Subject: FW: 24/00391/FULHIGHWAYS RESPONSE no objec 21 Bartlett Road, Redditch - Lister Tube

I have no highway objections to the proposed erecting of a lightweight storage building of 148 square metres (GIA) – no highway implications.

Proposed Site, new structure shown maroon

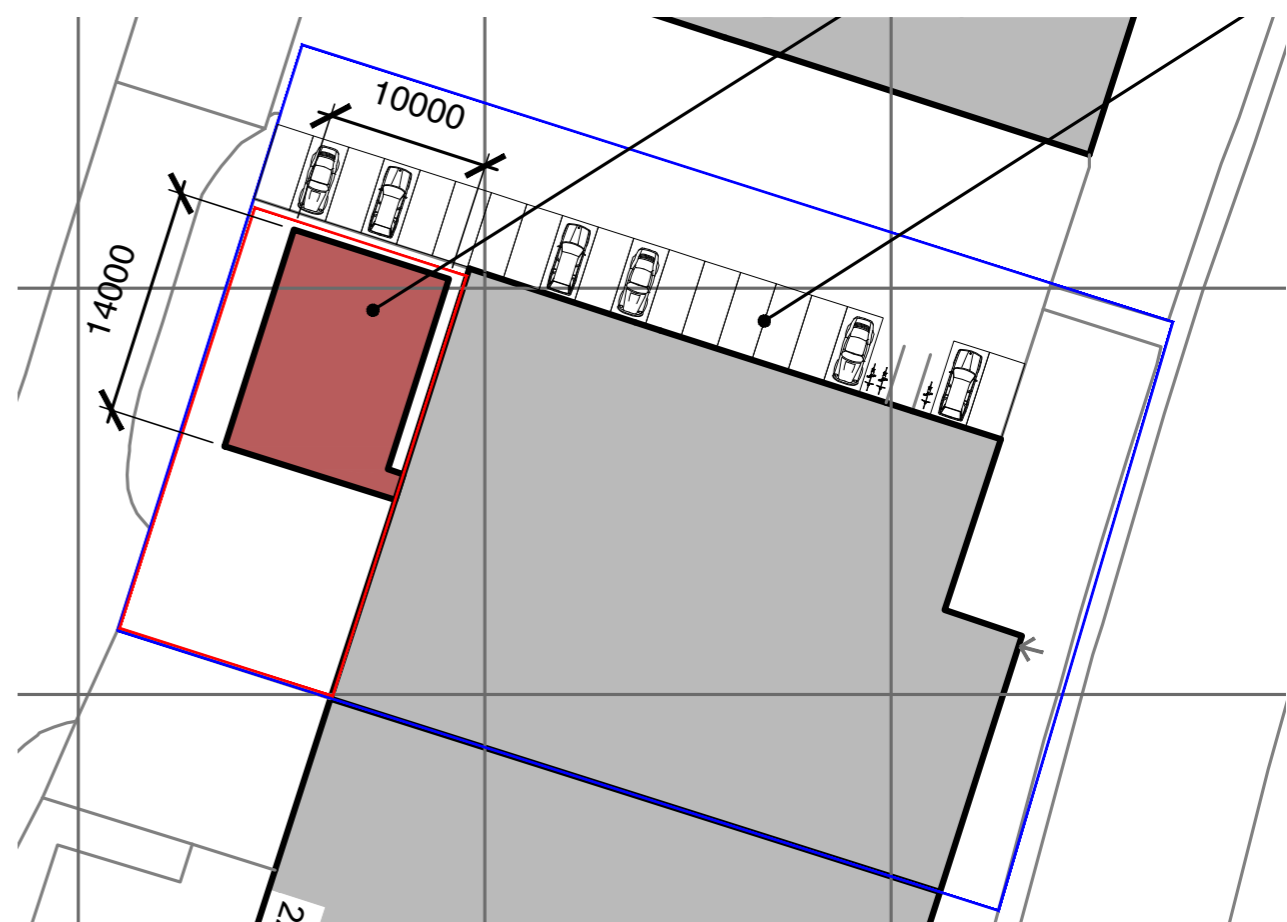
Regarding car parking it would appear that the building would displace the opportunity for car parking in the forecourt and for the floor area of a building in the same primary B2 use as the main building, to accord with the Worcestershire County Highways Streetscape Design Guide, there would need to be 1 space per 35sqm = 4 parking spaces. Also, I have calculated that the existing building in B2 use ought to have 23 parking spaces.

Since reliance seems to be placed operationally on the land adjacent to the north-east boundary if this is in the ownership of the applicant I would suggest you could draw a block plan plotting the available parking. Moreover, a supporting statement addressing this parking issue would be necessary.

Parking on site will remain unaffected. There is provision on site for up to 19 cars to be parked. There are 15 full time members of staff so there is plenty of parking available even if all staff members chose to drive to work. This is of course an unlikely / worst case scenario given the good public transport links to the site and other sustainable transport options available that staff are encouraged to choose.
